National Infrastructure Planning  
Temple Quay House  
2 The Square  
Bristol, BS1 6PN

Our Ref: EN010127

### **Application by Mallard Pass Solar Farm Limited for an Order Granting Development Consent for the Mallard Pass Solar Project**

#### **Advice following issue of decision to accept the application for examination**

### Traffic Regulation Measures Plans - Temporary Road Closures

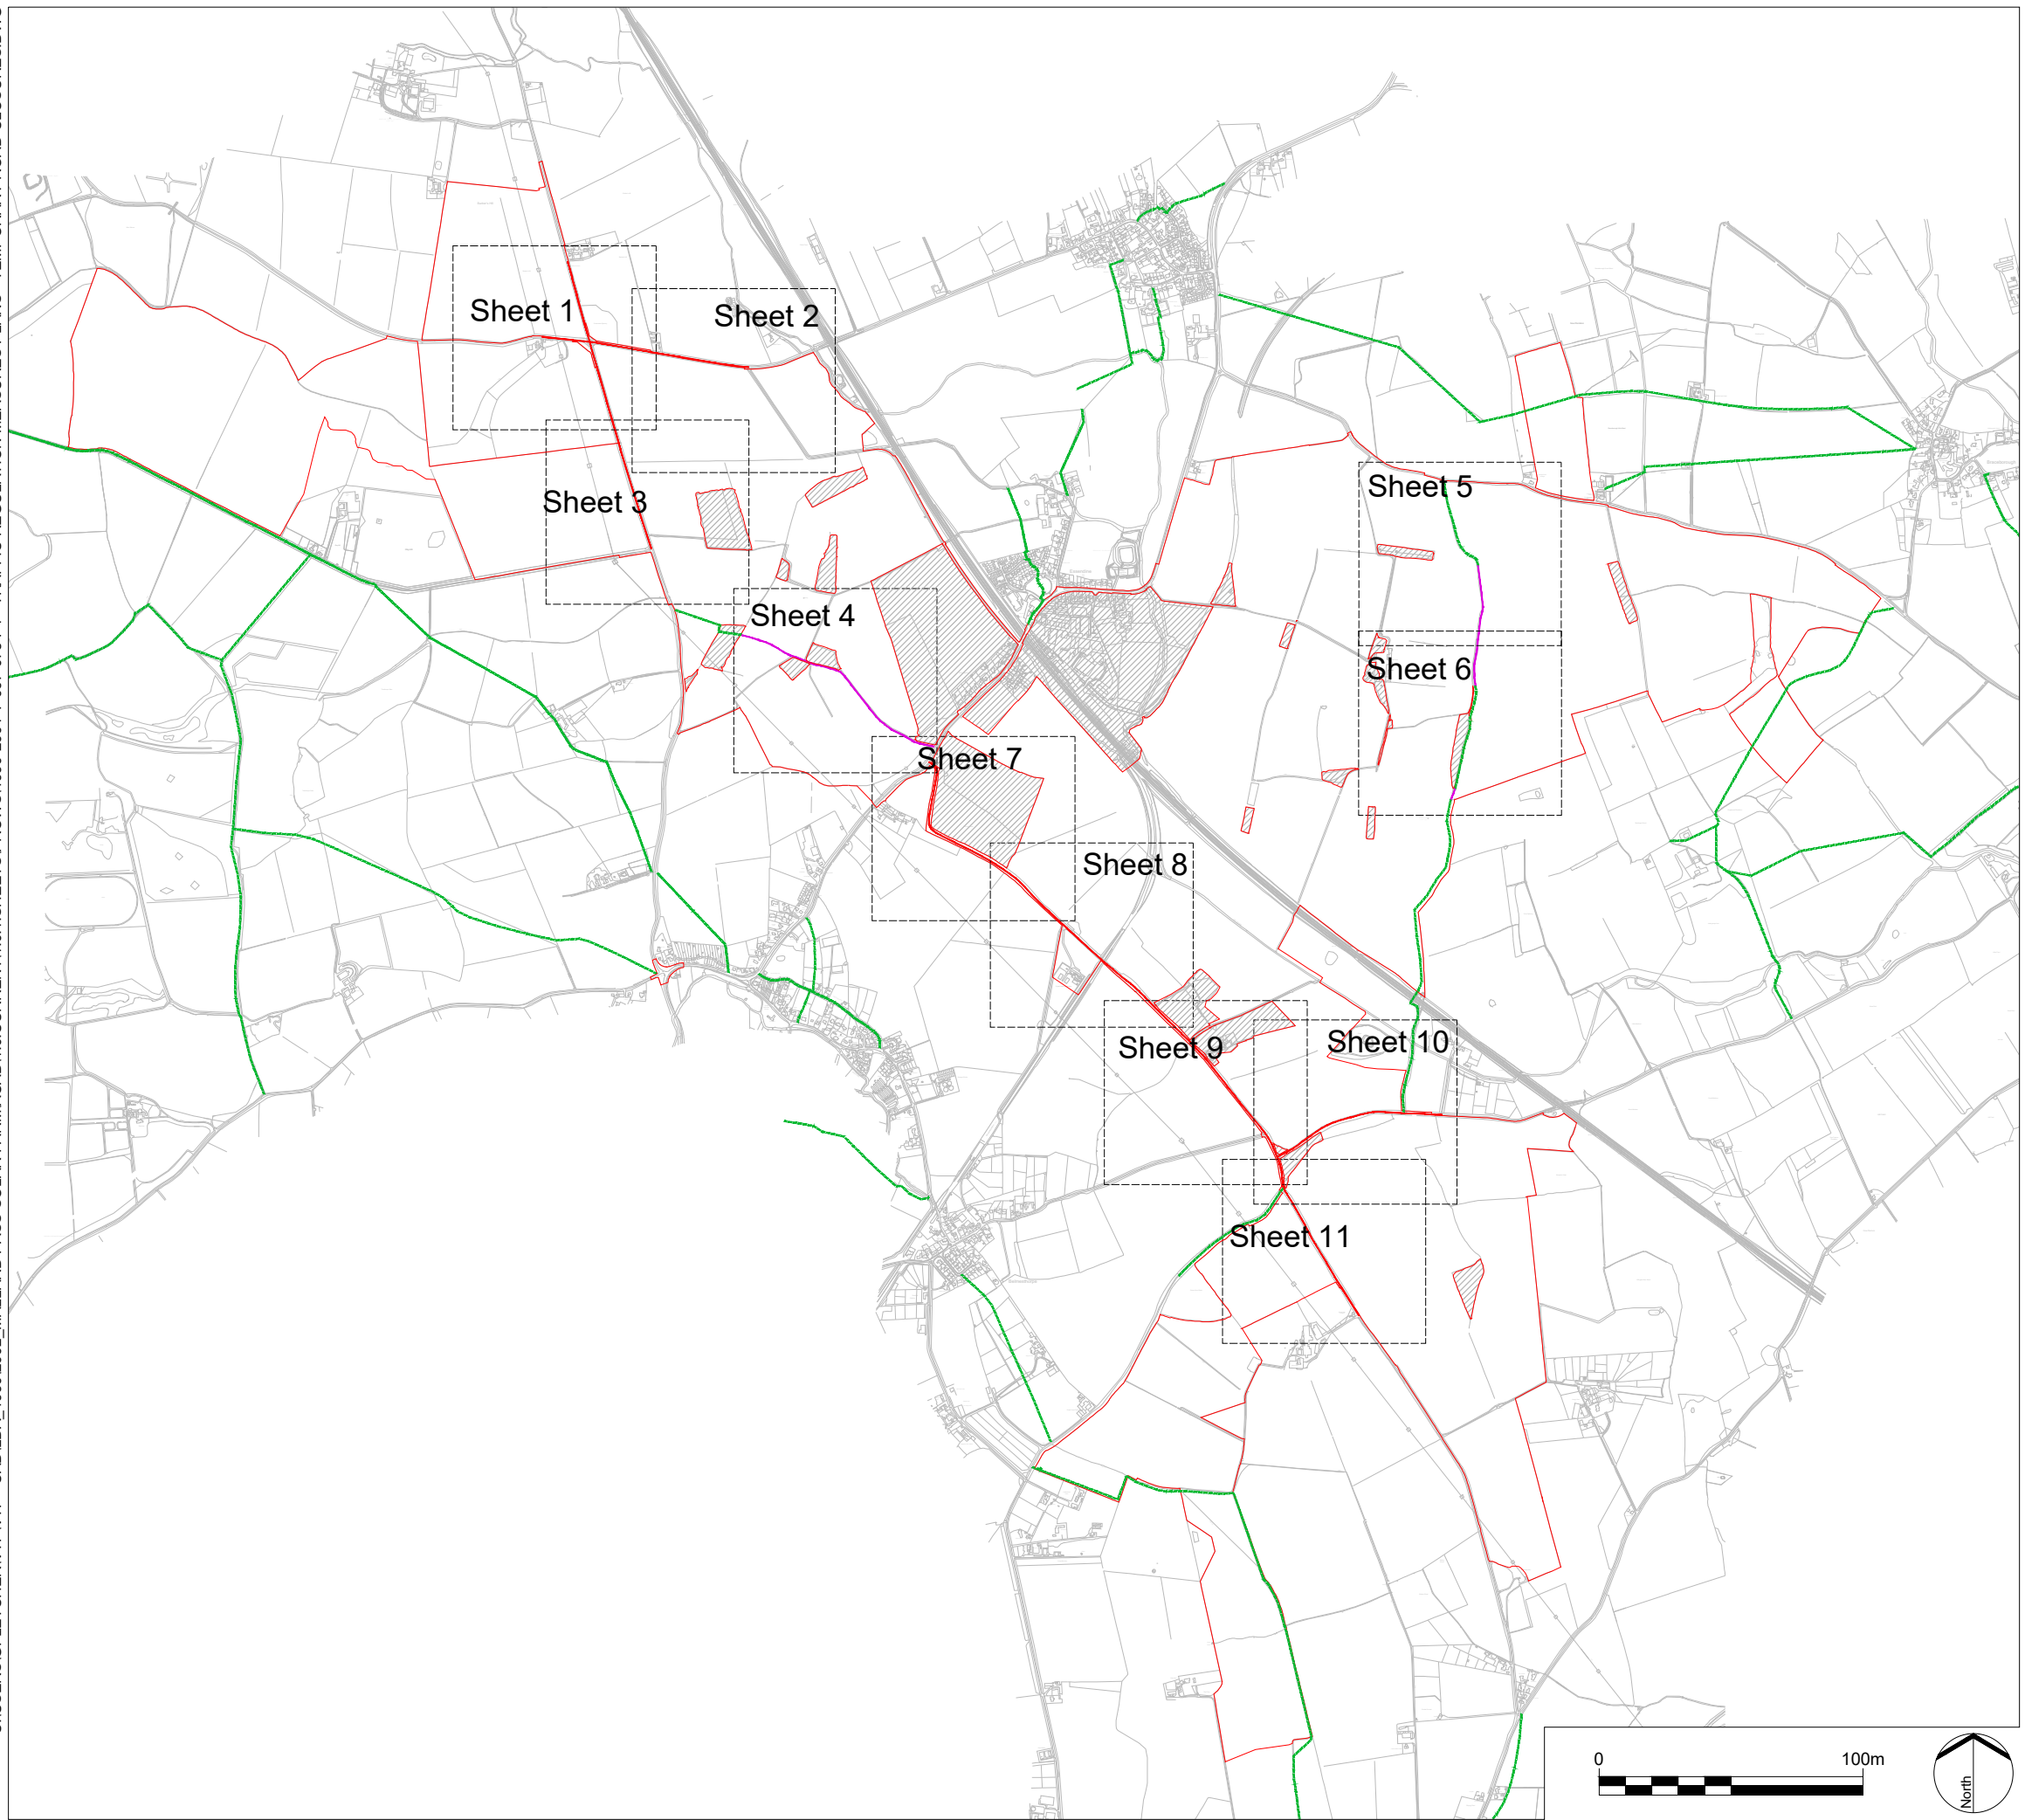
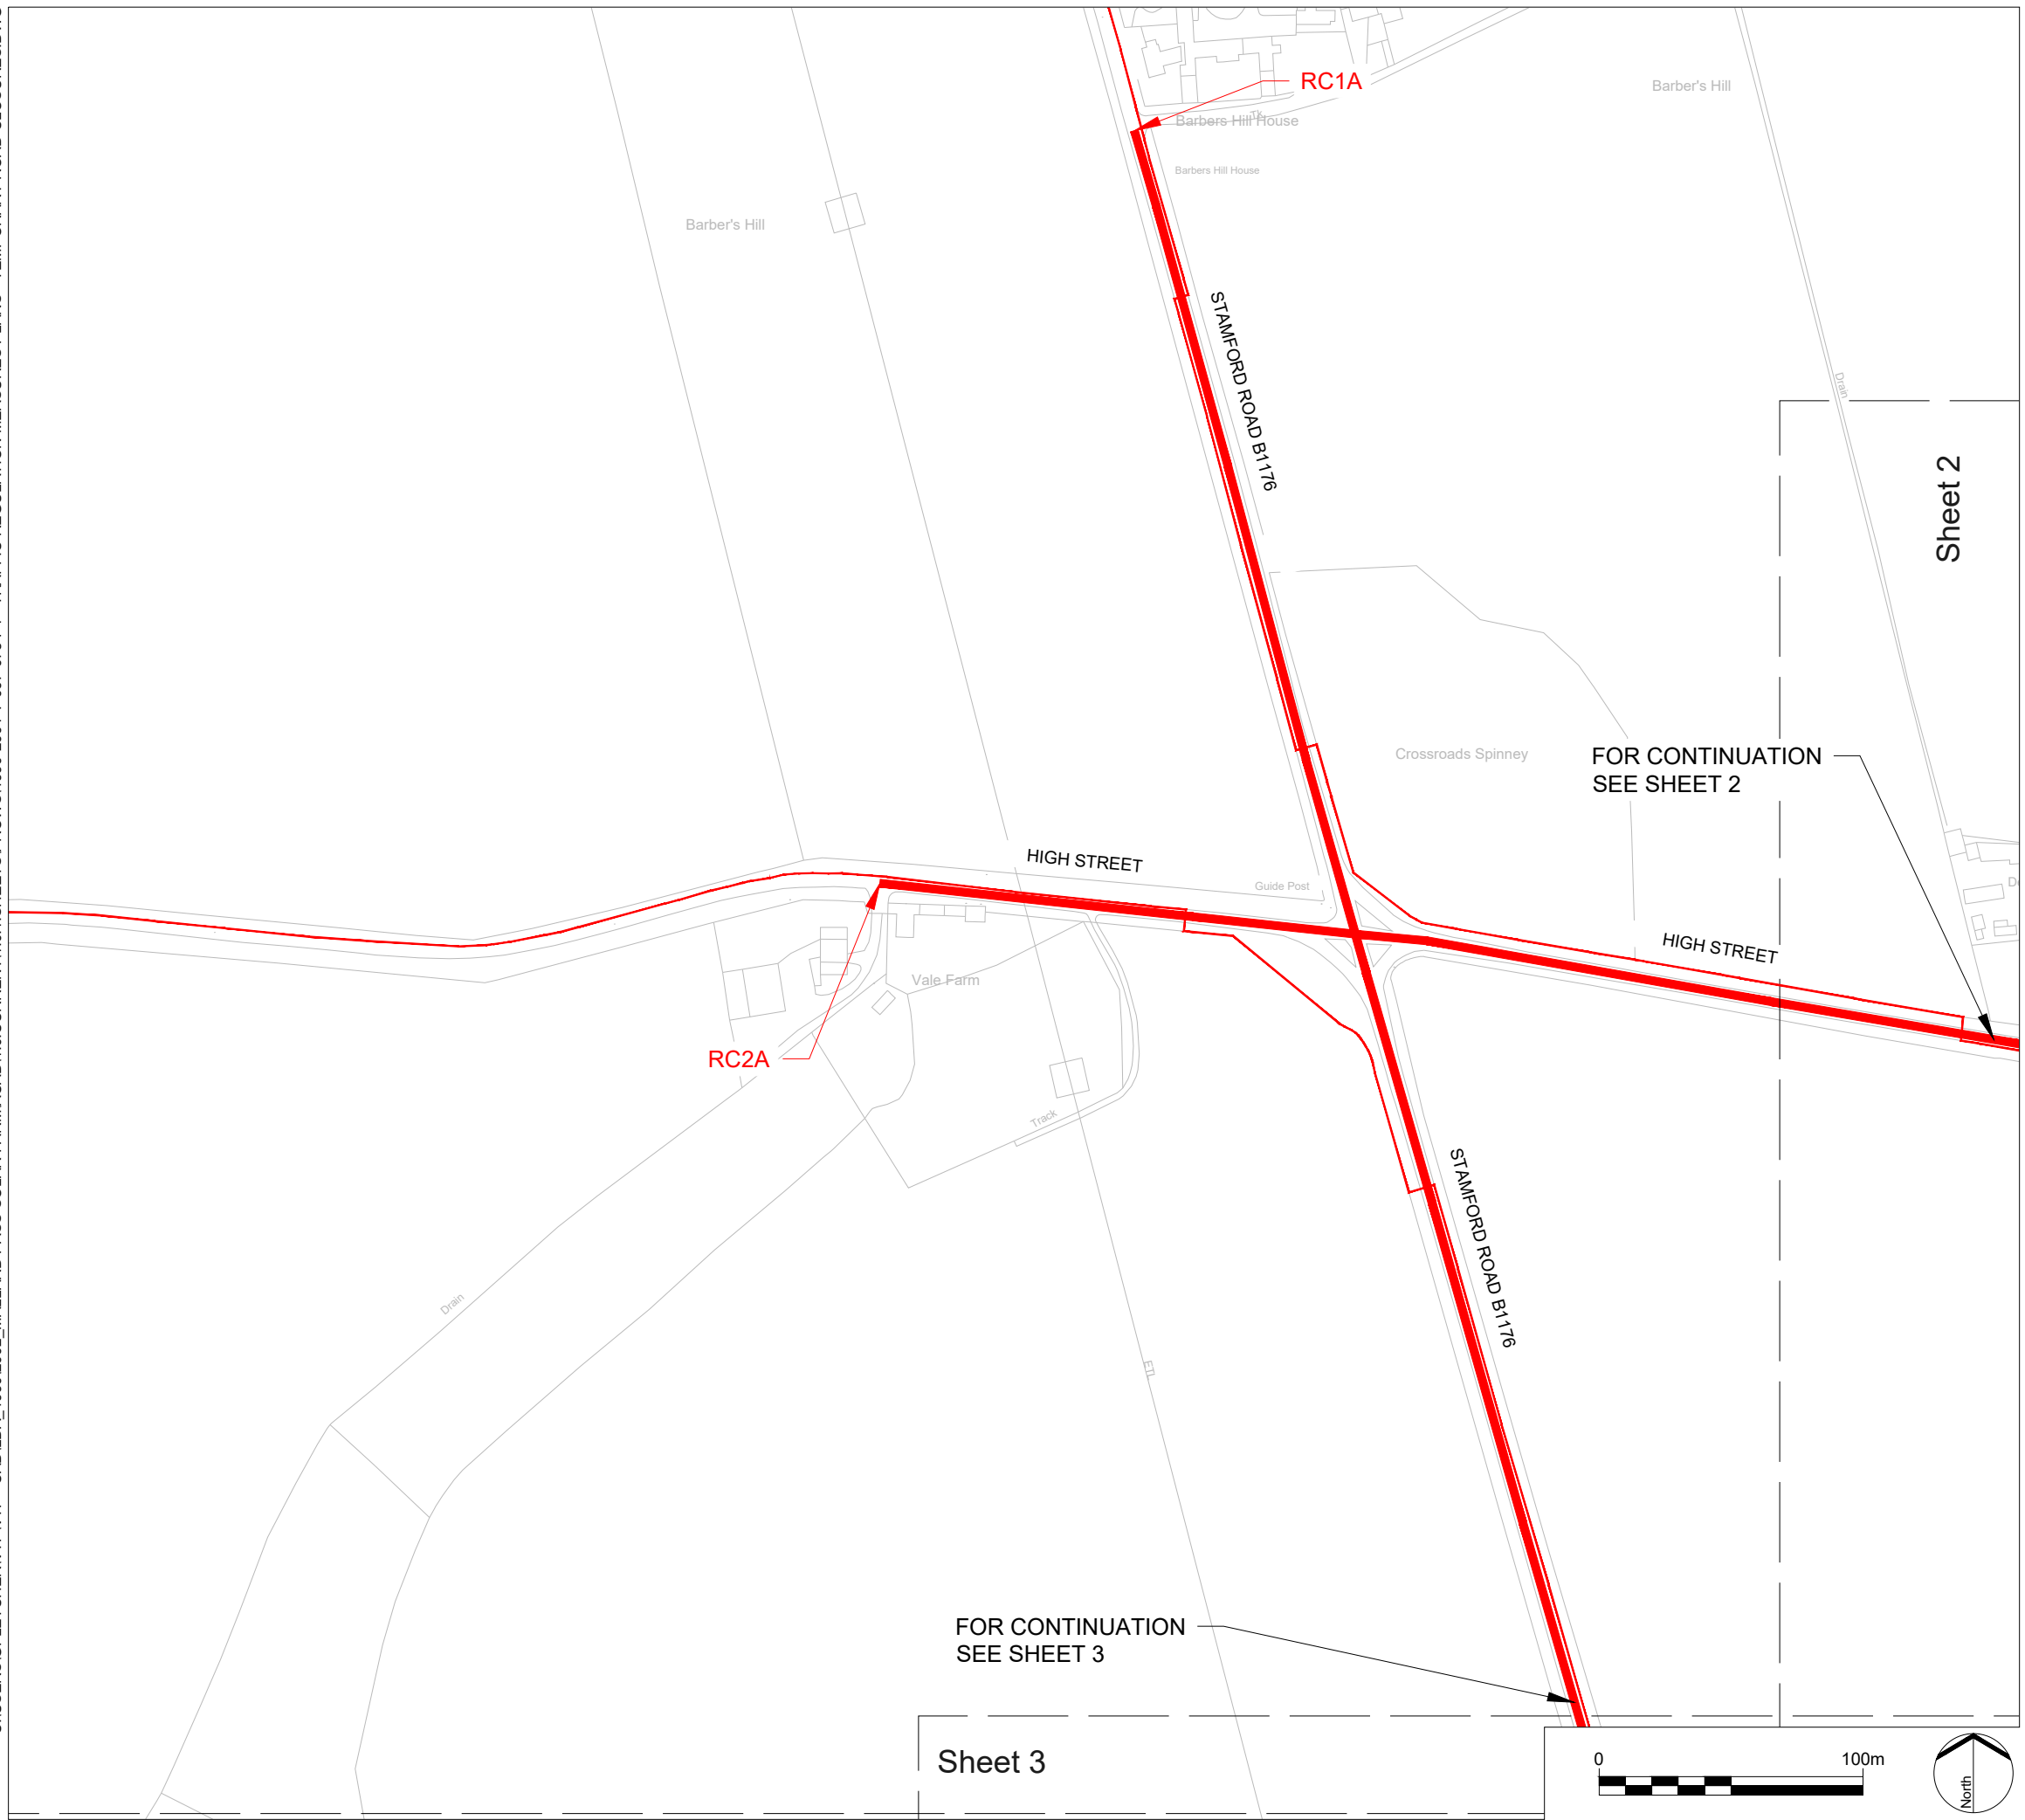
For clarity and to help understanding, existing public footpaths (public rights of way) should be marked and the plans more clearly notated to reflect the proposals, including differentiating works to footpaths and roads.
